**Re: Request for Information 5 for File No. SUB16-011
7239 LLC 2-lot Short Plat
Core Project No. 16082**

The purpose of this letter is to provide a response to the Request for Information 5 for File No. SUB16-011 dated April 10, 2019. We have addressed each comment and revised the plan/documentation accordingly. This letter contains the review comments immediately followed by our response to each in bold lettering.

7239 SE 27TH STREET SHORT PLAT

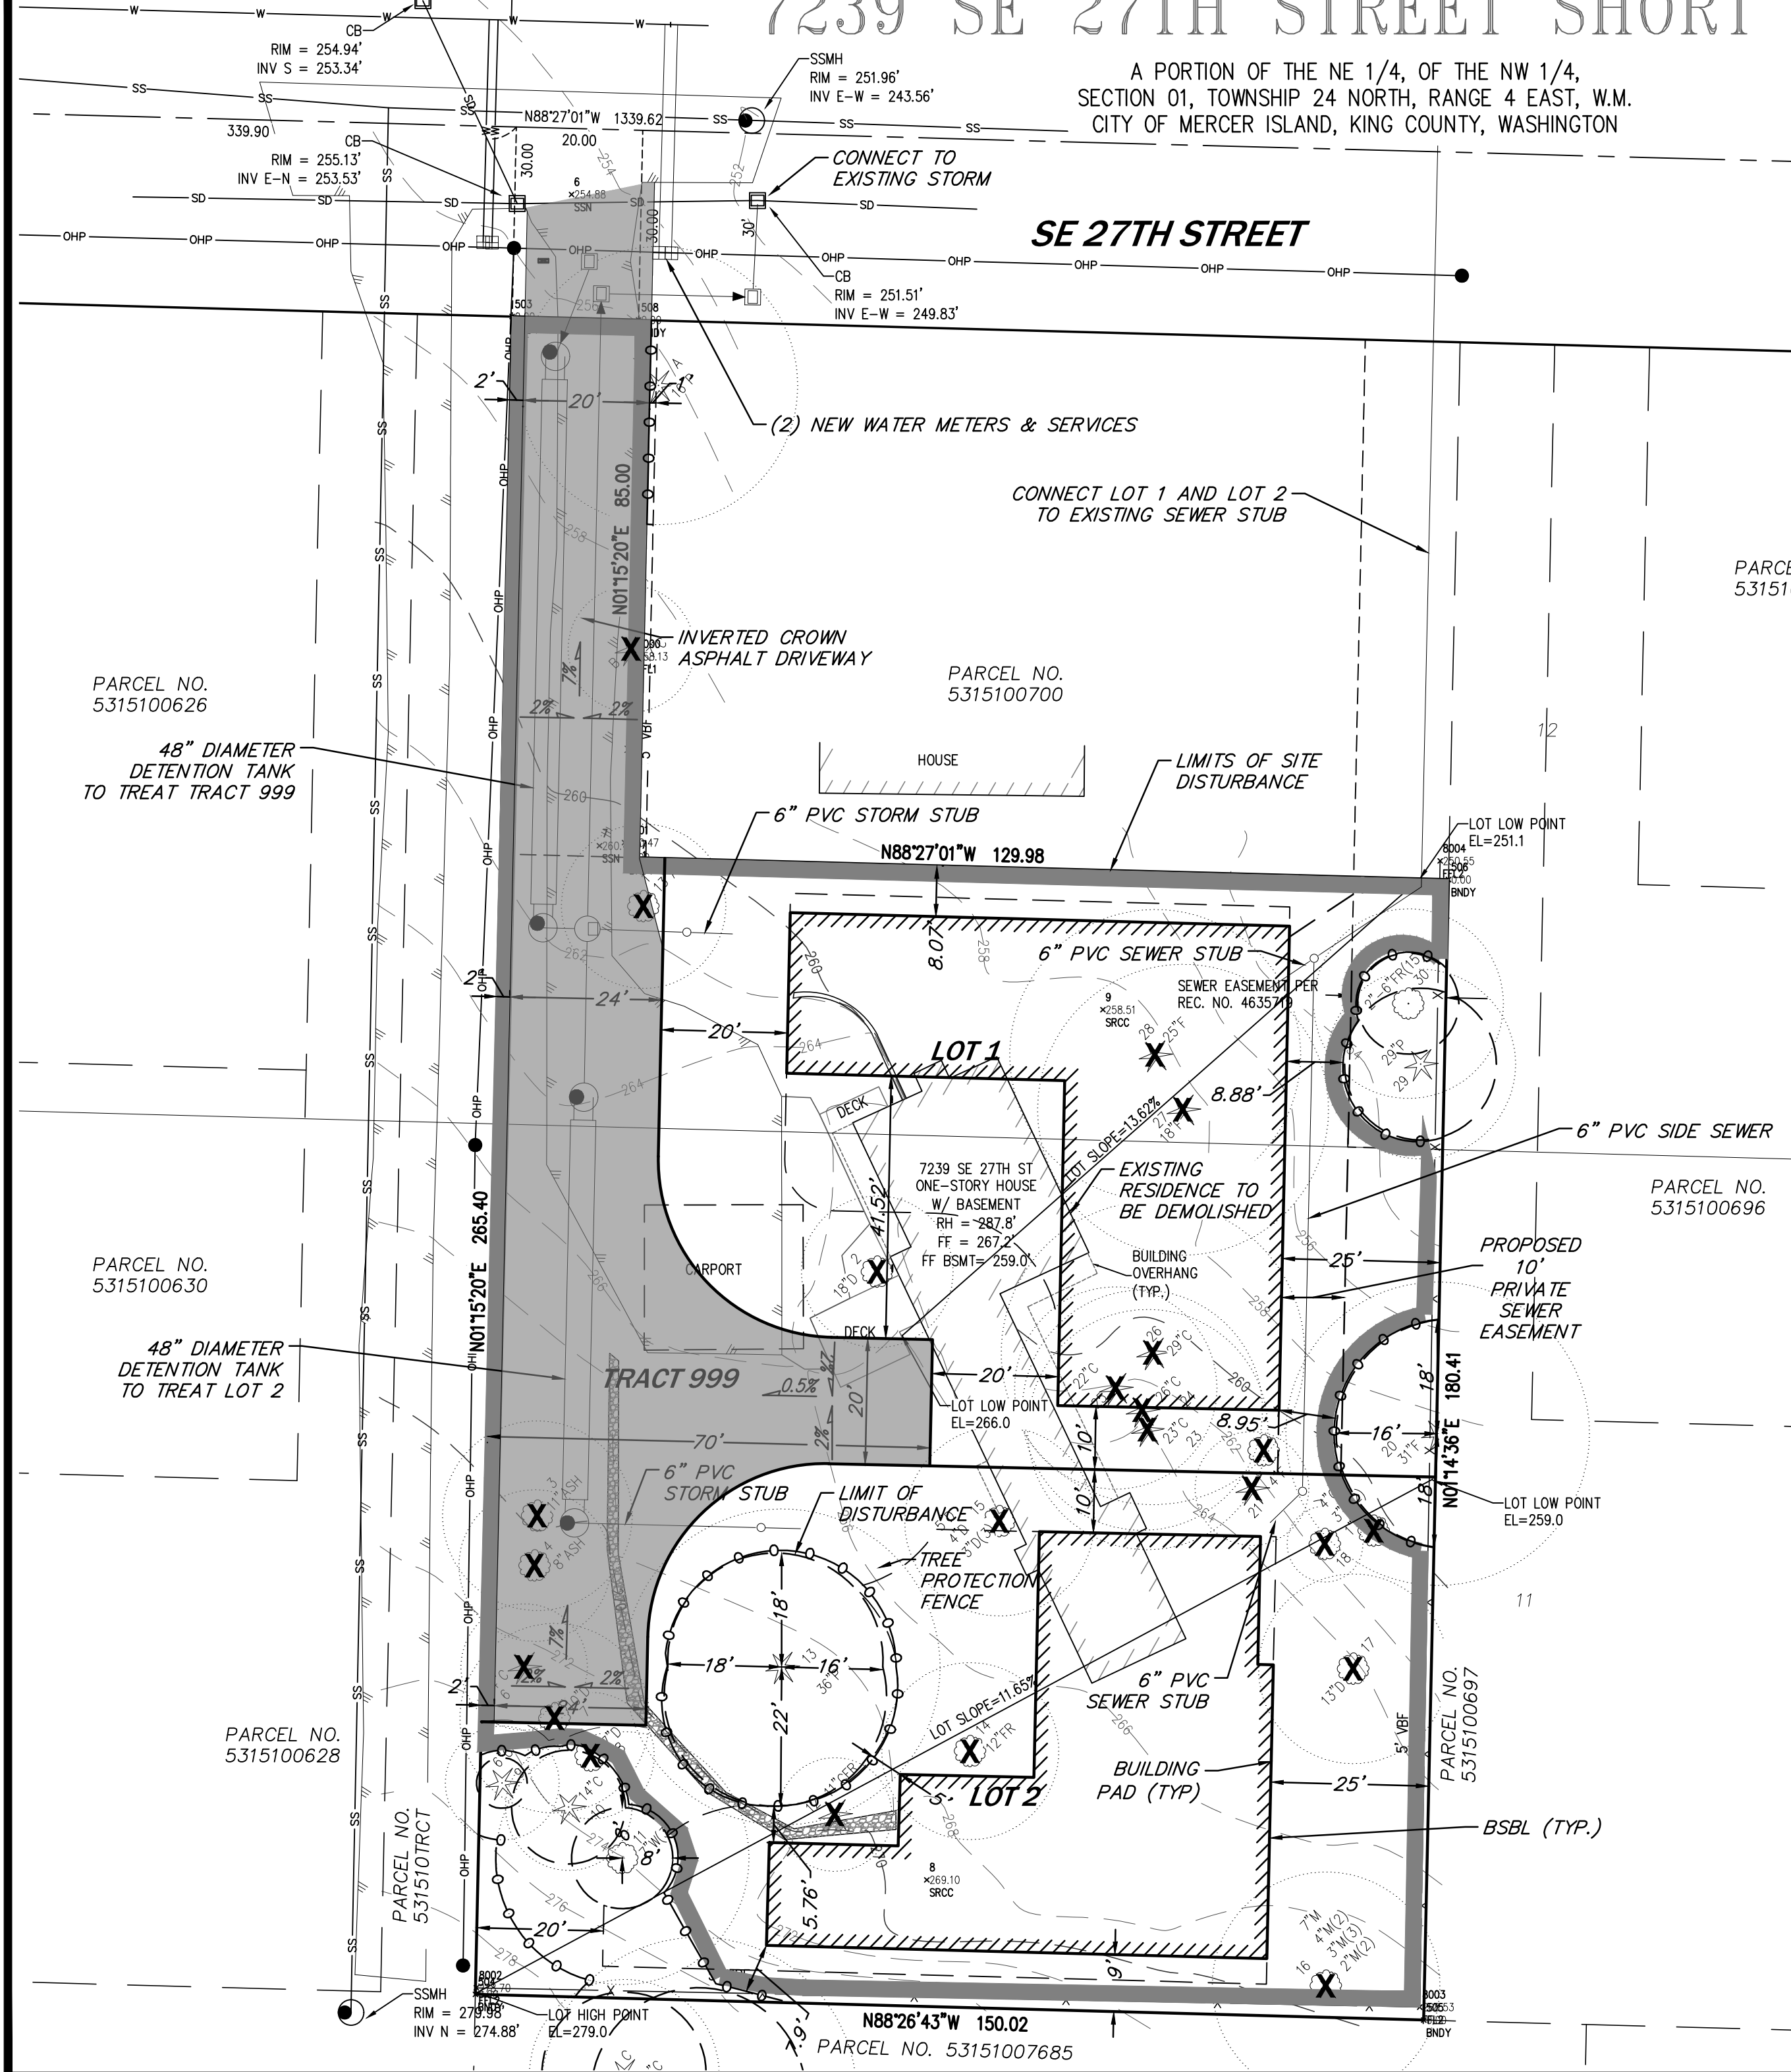
1. A site plan showing limits of disturbance (LOD) based on either those shown in the arborist report from Greenforest Incorporated dated 12/27/17 (using the dripline radius or LOD radius, whichever is greater) or air excavation of tree roots.

2. A site plan showing building pads consistent with the limits of disturbance.

The one thing I noticed is that there should be 5' of distance between the building pad and the tree protection. This is for access to build the building and over excavation. Please confirm this on the plans as it is not clear.

I took a quick look. I think the compiled Arborist report helps clarify the situation. It calls out the limits of allowable disturbance between tree 13 and any impacts at 22'. Could you update/callout that on with that distance? And insure there is at least 5' between the tree protection and tree protection. The tree fence will be chain link.
Once this is updated I think it will be ready to submit.

Response: A new site plan showing limits of disturbance based on most current and compiled arborist report (by Tree Solutions, dated September 3, 2021) reviewed and approved by City staff (by email from John Kenney, City Arborist, dated September 13, 2021), has been included with this submittal. Also included is the compiled arborist report. The report describes how the limits of disturbances reported were determined including air excavation of tree roots. The new site plan reflects these LODs and corresponding tree protection fencing.

Response: The site plan included with this submittal includes edits to the buildable pads to reflect changes and updates to the limits of disturbance for all saved trees. Note that a 5' setback is provided between new tree protection fencing (set at the new LODs) and the buildable pads.

The attached update has the tree protection fencing at or just outside the limits of disturbance for the saved trees and then dimensions from the tree protection to the buildable pad. There are several locations throughout the site with dimensions shown and in all cases there is 5 feet minimum between protection fence and buildable pad.

I have attached an updated Short Plat Sheet 3 that has been edited to be consistent with the LOD table on page 1 of the compiled report. It lists the LOD for Tree 13 as 18 feet to the north, 16 feet to the east, 22 feet to the south and 18 feet to the west. These are reflected on the attached plat sheet.
